**Our ref:** AF/TR/Q230135  
**Your ref:** 68663/APP/2023/1933  
**Email:** tim.rainbird@quod.com  
**Date:** 17<sup>th</sup> October 2023

### Former B&M Unit, 217 High Street, Yiewsley, West Drayton UB7 7GN Planning Application Reference 68663/APP/2023/1933

We write on behalf of our client, TJ Morris Limited ('the Applicant'), in respect of the above pending application to regenerate the former B&M site at 217 High Street, Yiewsley ('the Application Site'). Specifically, we provide a response to the comments raised by Hillingdon Council's Urban Design Officer ('UDO') received via email on the 11<sup>th</sup> September 2023.

DRAWING TITLE
Proposed Site Plan

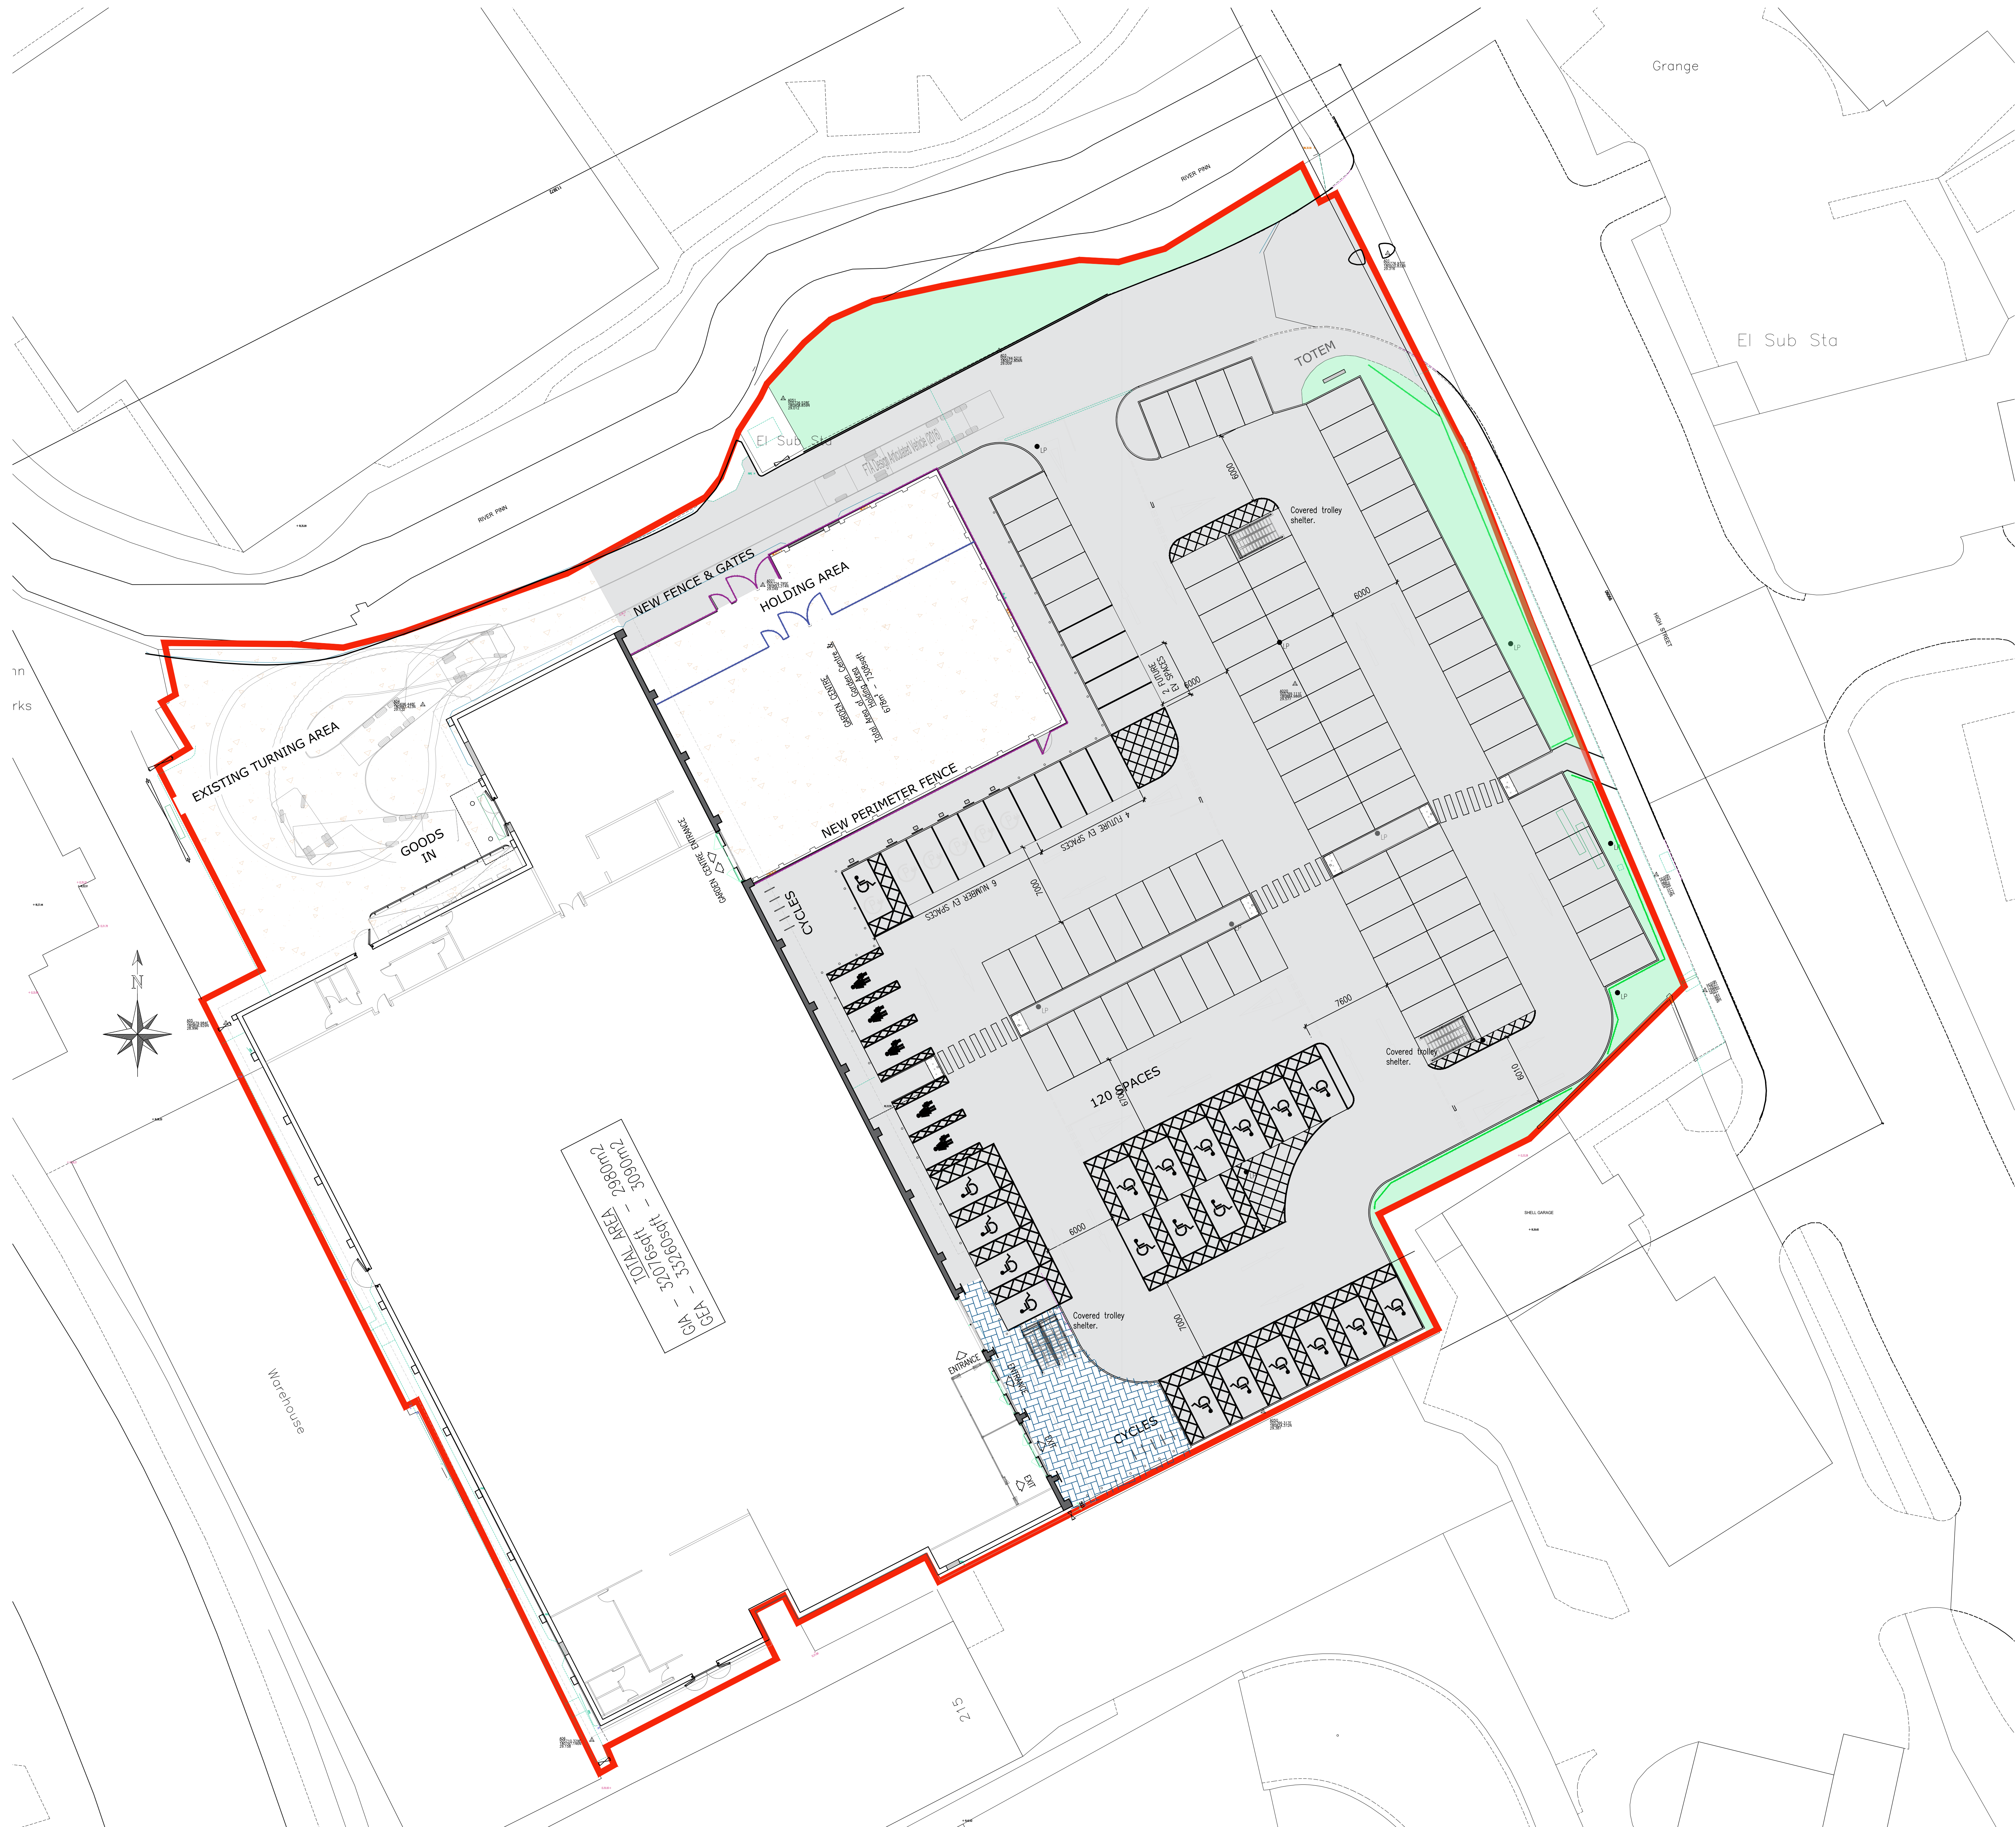
The UDO also suggests the existing tree pits within the car park should be retained and planted with trees. A photograph of the existing situation is provided below illustrating that the tree pits do not include any trees and are overgrown.

Retaining the existing tree pits within the car park is not viable given it would adversely impact on car parking numbers together with causing potential issues and complexities with customer parking. For these reasons, it is not possible to retain the tree pits.

However, as set out in the application submission, the application does not propose the removal of any existing trees and instead proposes to plant 15no. new trees. The proposals will therefore result in an overall benefit in this respect.
